**Pick n Payless Metal Recovery and Recycling Facility (SSD-8375)
Response to Submissions**

PICK N PAYLESS METAL RECOVERY AND RECYCLING FACILITY (SSD-8375)
DEPARTMENT OF PLANNING, INDUSTRY AND ENVIRONMENT – KEY ISSUES

Datum: A.H.D.

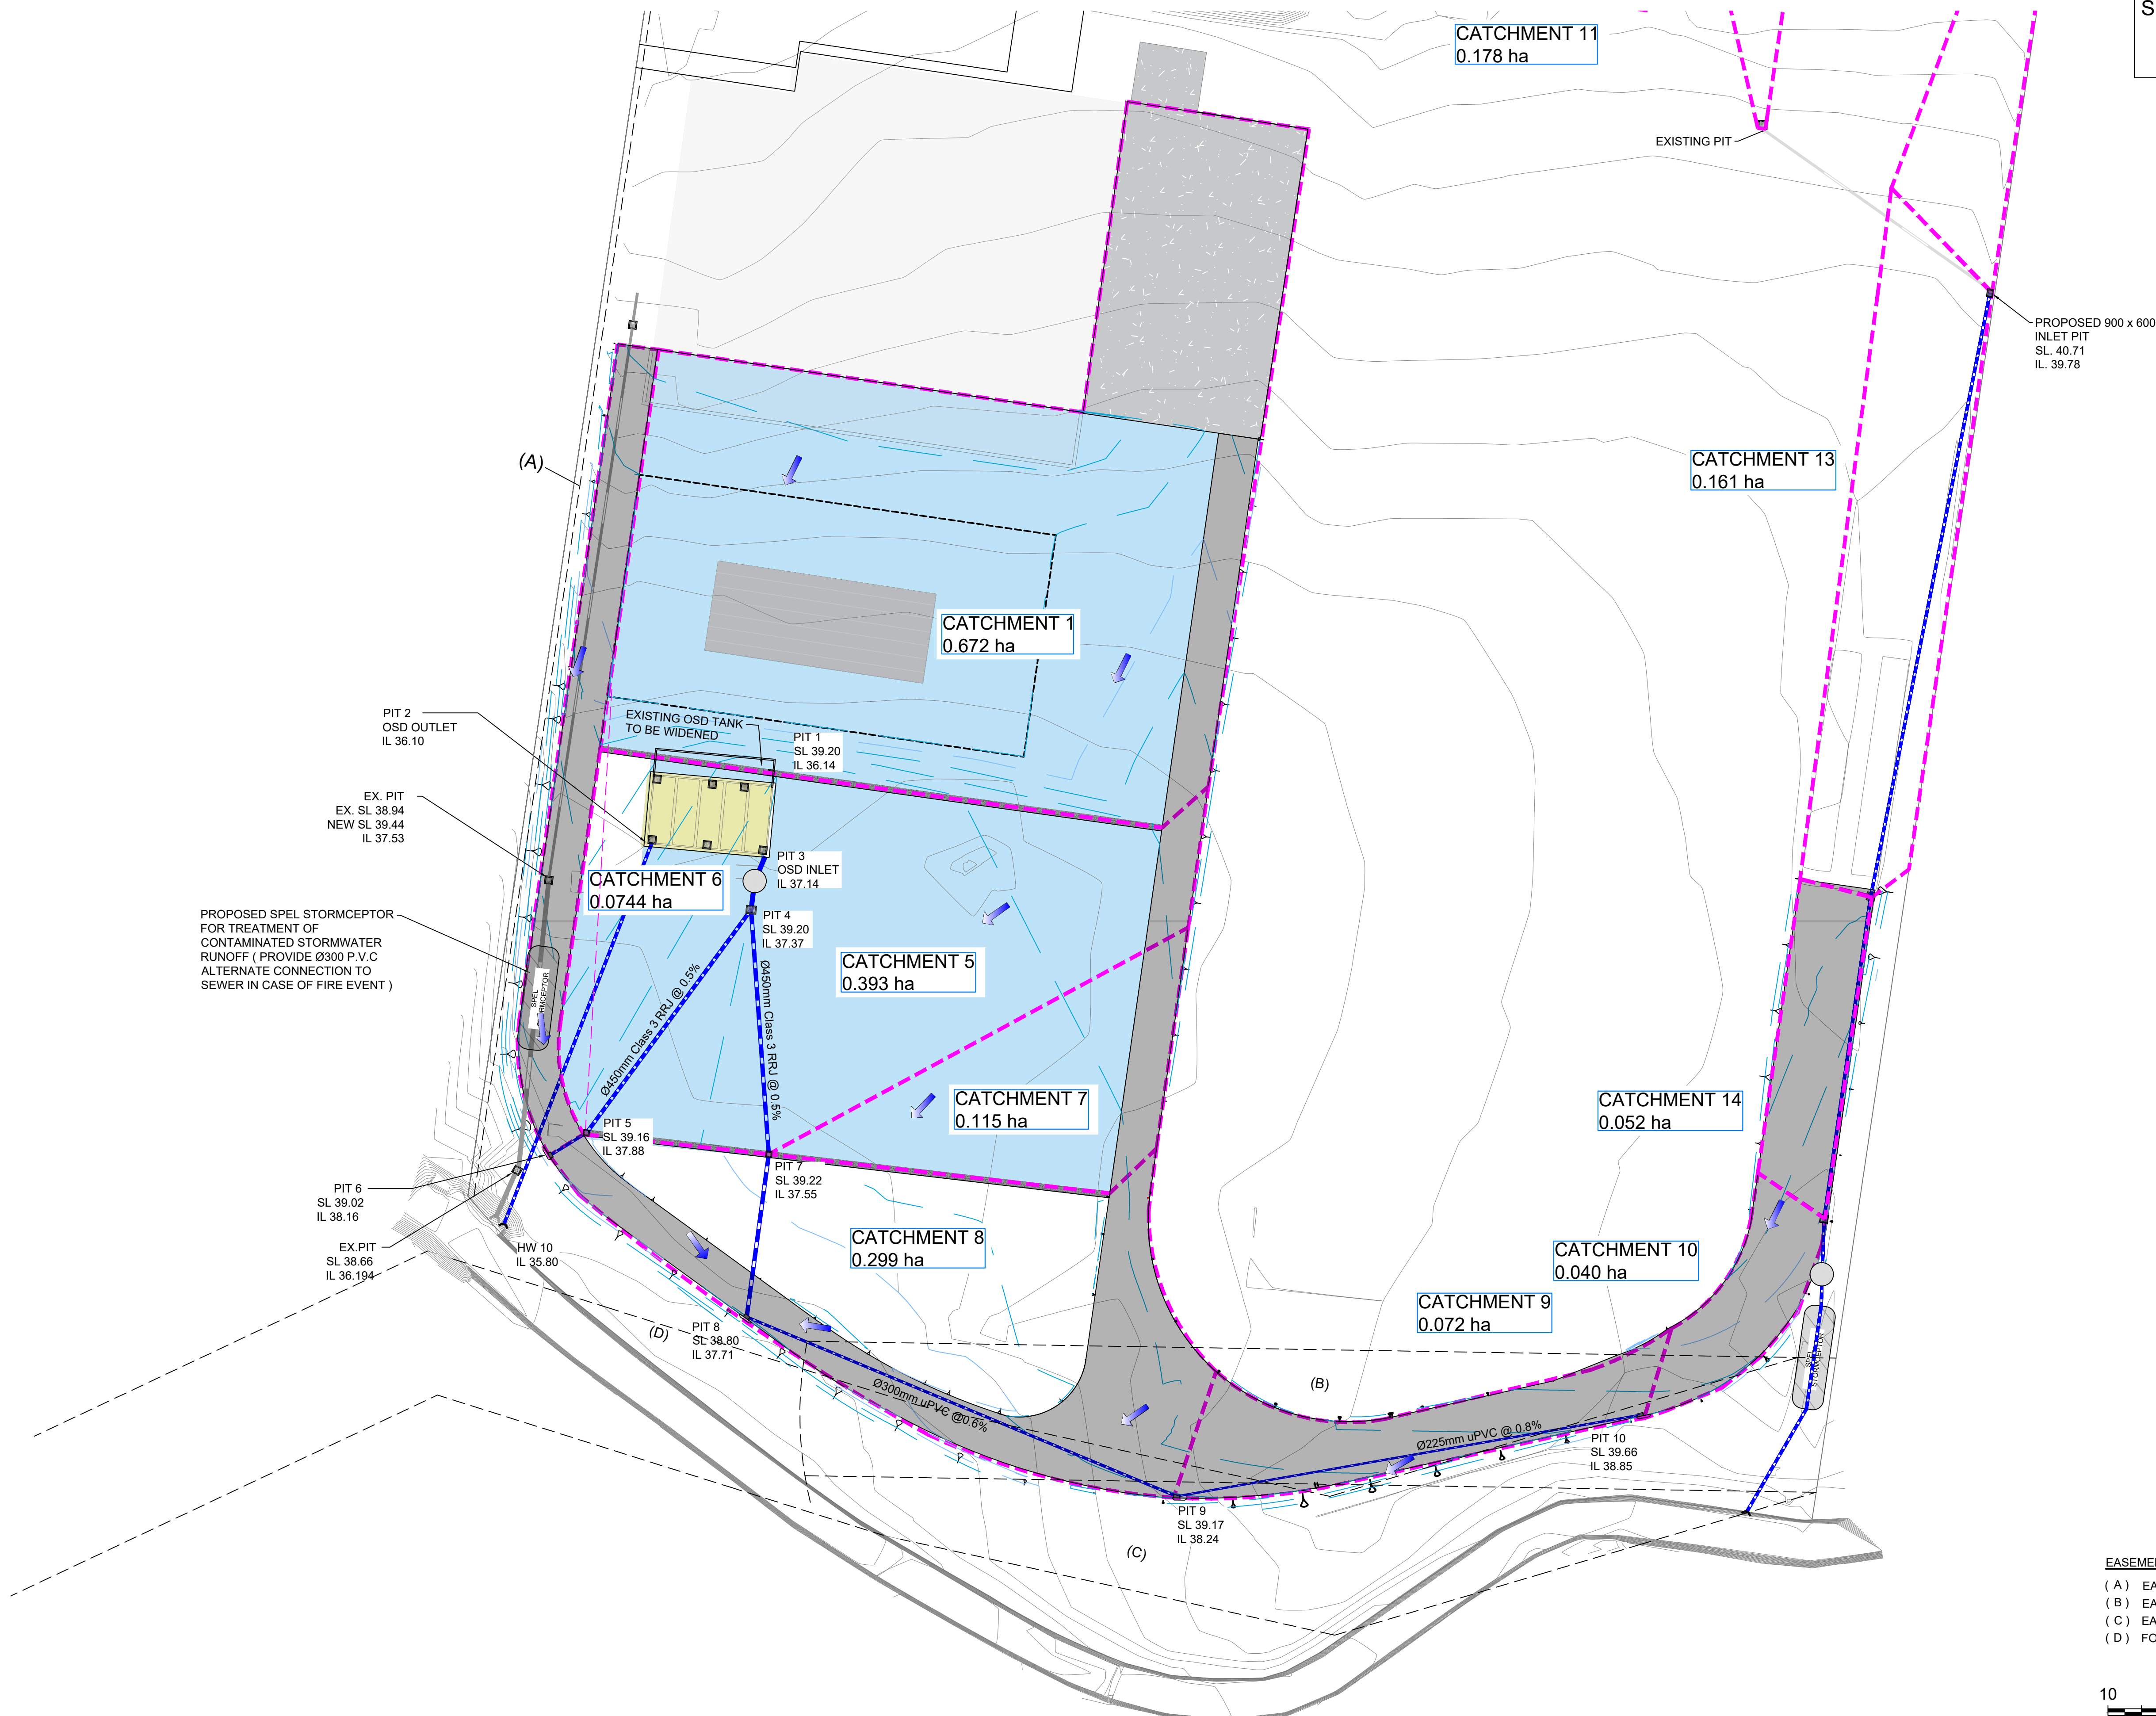
9. The Site Plan (CC160136-DA Sheets, Revision A) in the SWR shows a SPEL Stormceptor (to the south-west of the below-ground OSD pond) will be installed for treatment of contaminated stormwater runoff. Please provide the capacity of the proposed SPEL Stormceptor.

**Figure 5:** Existing Driveway Survey Results

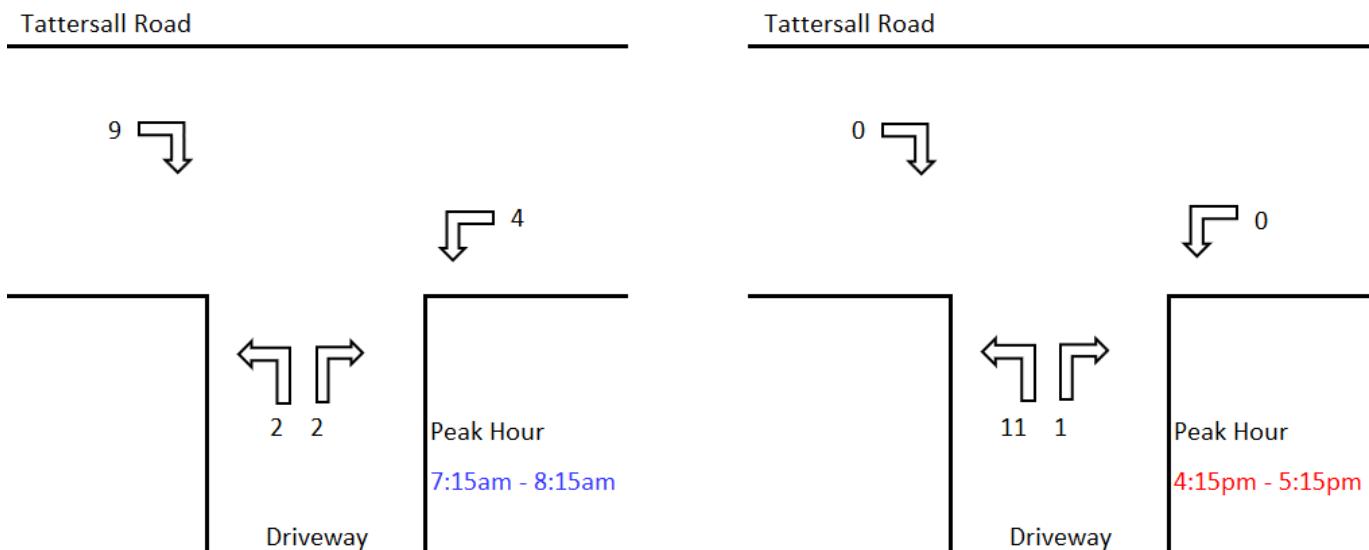
19. The TIA does not provide haulage routes for construction and operational trucks. Please clarify the proposed haulage routes.
20. There are three driveways serving the site. Figure 5 Existing Driveway Survey Results and Figure 7: Proposed Development Traffic Generation do not specify to which driveway these figures refer. Please clarify in the RtS report.

21. Figures 5 and 7 of the TIA show in both the existing and proposed developments, during both AM and PM peak hours, there are/will be vehicles approaching the site from west via Vardys Road and Tattersall Road. Meanwhile, there are/will be vehicles leaving the site westbound through Tattersall Road and Vardys Road. However, Figures 8 and 9 show the proposed AM and PM trip distributions

exclude vehicles traveling through Vardys Road and Tattersall Road. Please clarify the discrepancy in the RtS report.
